Please see the response form our consultant regarding condition 16.

I have reviewed the report further to the EHO's comments and provide the following response that should be forwarded on.

Figure 3 – Trial Hole Plan

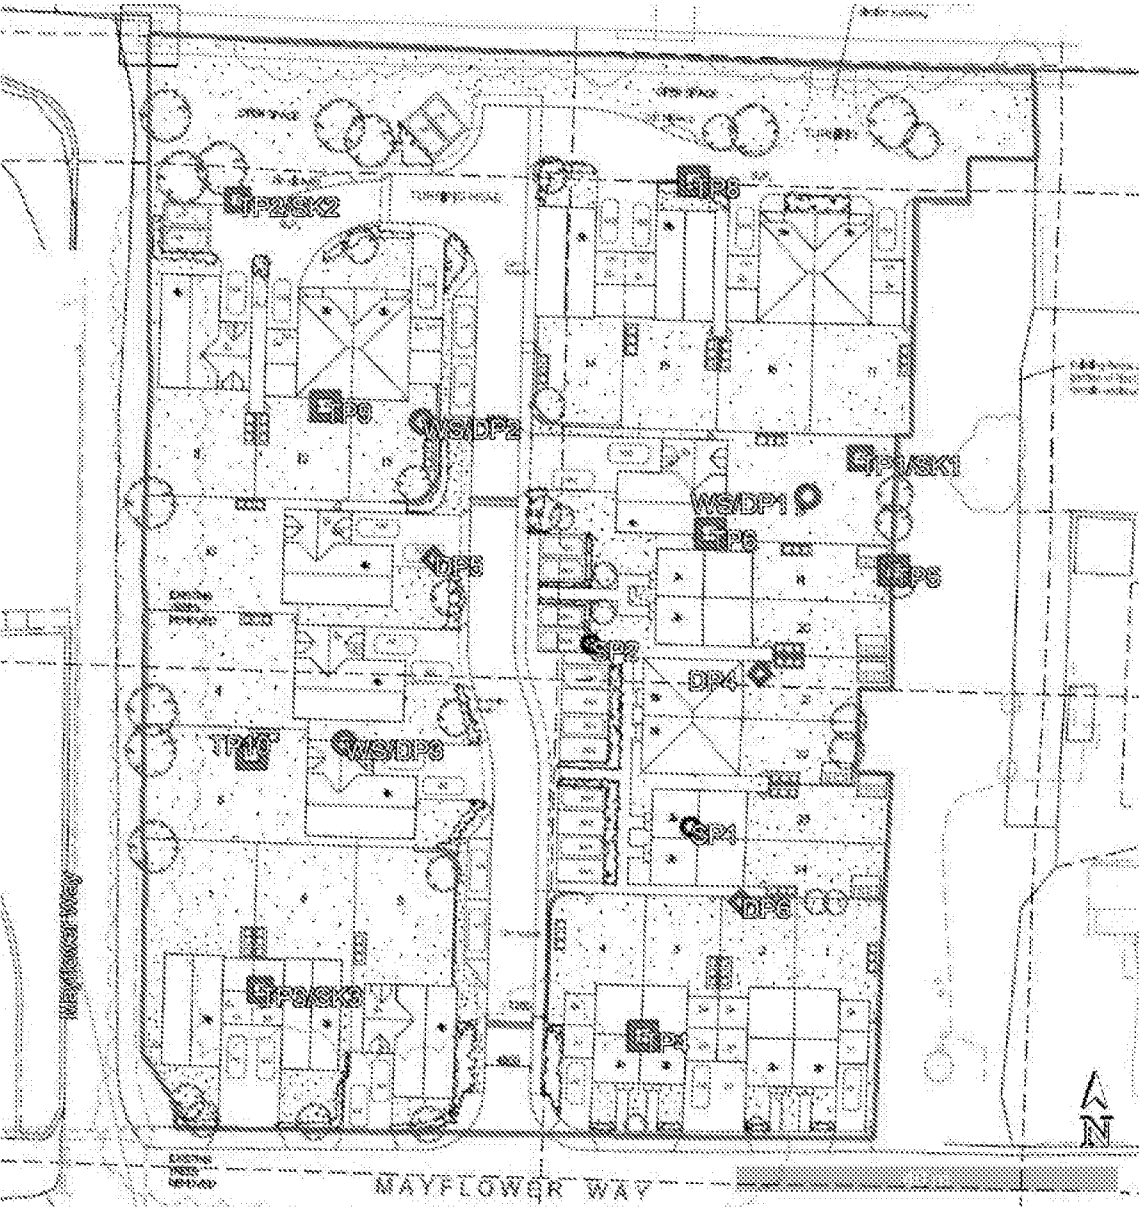
- 1) *the CGIR identified an exceedance of lead at 0.10 metres depth and stated that based on the proposed development plan, no remediation was required, however no management of this exceedance is mentioned and no subsequent sampling of the garden areas was undertaken;*

The area where the elevated lead concentration was encountered was beneath the proposed buildings of plot 6 & 7 and at shallow depth. The attached drawings show that site levels were to be reduced in this area by between 200 and 300mm and therefore the encountered lead would have been removed during construction and, even if present at greater depth, would have been covered so that it would not present a risk to the end-user. With regards to the garden areas of plots 6/7, it is acknowledged that no supplementary sampling testing has been undertaken, however, given the proposed site level changes across these garden areas along with the need to replace the surface soils with an appropriate growing medium / topsoil then the same would apply to these areas i.e. removal of material to facilitate level change and further replacement of near surface soil with imported clean material.

Obviously any imported topsoil etc would need to be accompanied by appropriate certification or independently tested and such information provided to the regulator.

Gas protection to level **CS2**.

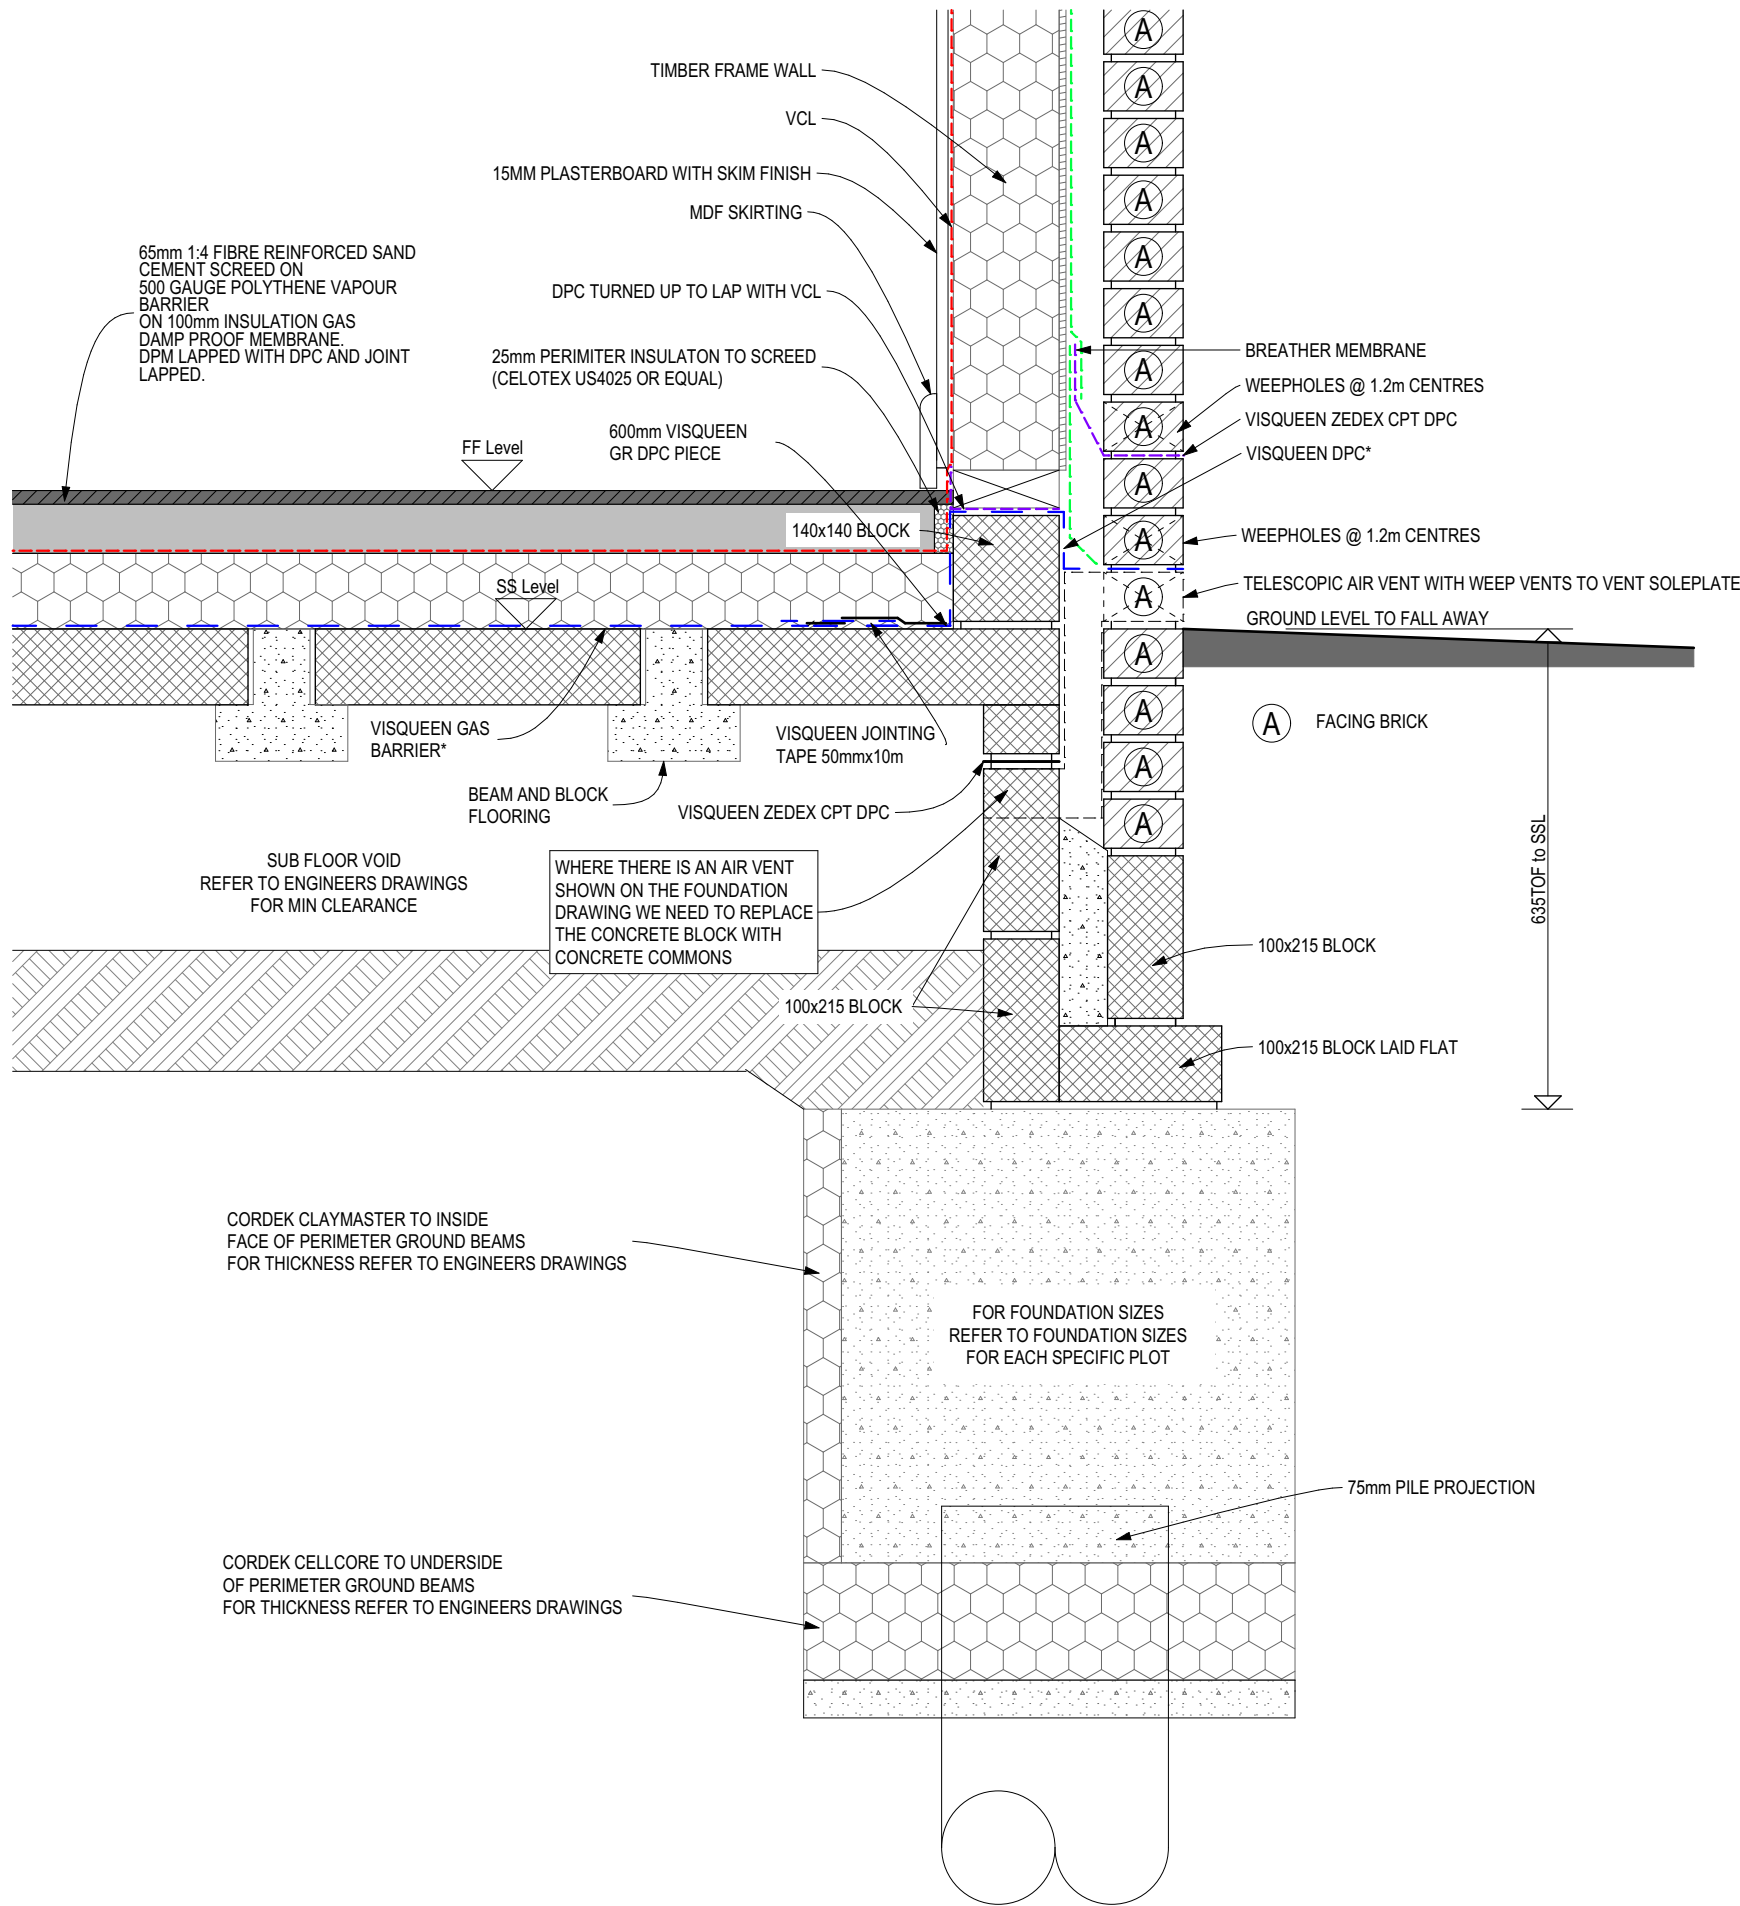
- 2) *the SGRA concludes that gas protection measures are likely to be required, however no detail is provided.*

- the CGIR identified an exceedance of lead at 0.10 metres depth and stated that based on the proposed development plan, no remediation was required, however no management of this exceedance is mentioned and no subsequent sampling of the garden areas was undertaken;
- the SGRA concludes that gas protection measures are likely to be required, however no detail is provided.

I have attached our standard gas membrane detail for these situations as requested in their email.

The Local Authority should be provided with the appropriate cross section drawings relating to the gas membrane installation along with details of the intended membrane to satisfy CS-2.
